Development Application and Planning Proposal Review NSW Planning Portal Concurrence and Referral

Authority	Authority's Reference	Agency Concurrence and Referral	Authority Contact	Authority Notification	Submission Due	Submission Made
NSW Dept. of Planning, Housing & Infrastructure	SSD-80824235		Rasmus Altenkamp	18/06/2026	16/07/2026	22/06/2026

Address	Land Title
Bolong Road, Bomaderry	Lot 143 DP 1069758, Lot 3 DP 3885, Lot 1 DP 605942, Lots 5 & 6 DP 544730, Lot A DP 384559

Environmental Impact Statement (EIS) for the Air Liquide CO2 Processing Plant, Bomaderry. Construction and operation of CO2 processing plant with production capacity of 100,000 tonnes per annum of food grade CO2 including CO2 pipeline, plant and equipment and storage tanks.

Figure 4, Diagram of Electrical Infrastructure.

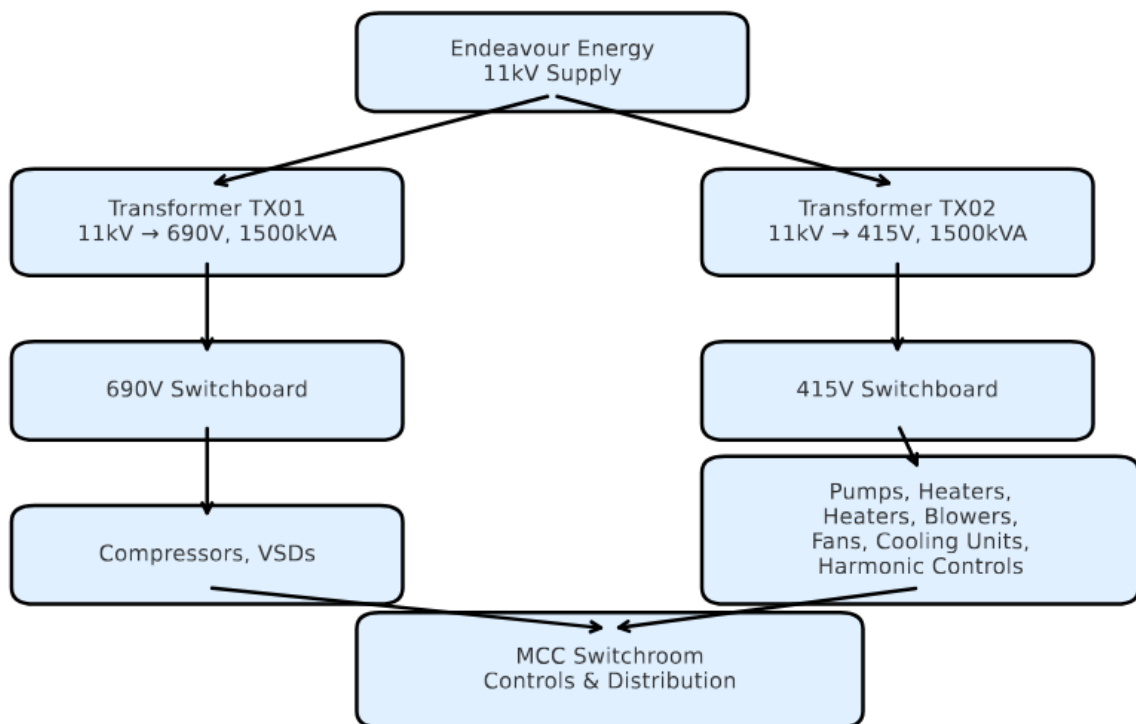
- From the following extract of the Infrastructure Requirements Report dated 17 July 2025 a high customer connection appears to be proposed. The applicant will need to continue to engage with Endeavour Energy's Customer Network Solutions Branch [who are responsible for managing the conditions of supply with the proponent and their Accredited Service Provider (ASP)] to complete the application for connection of load process.

Electrical loads are expected to include compression, liquefaction, and monitoring systems. Air Liquide is coordinating with Endeavour Energy to ensure adequate HV supply. Applications for connection agreements and works approvals will be submitted to Endeavour Energy and Shoalhaven Water in **Q4 2025**. An electrical tendering package is being prepared for distribution in Q3/Q4 2025. Electrical contractors will be certified in accordance with **AS/NZS 3000:2018 (Wiring Rules)** and hold a valid NSW Electrical Contractor Licence issued by NSW Fair Trading.
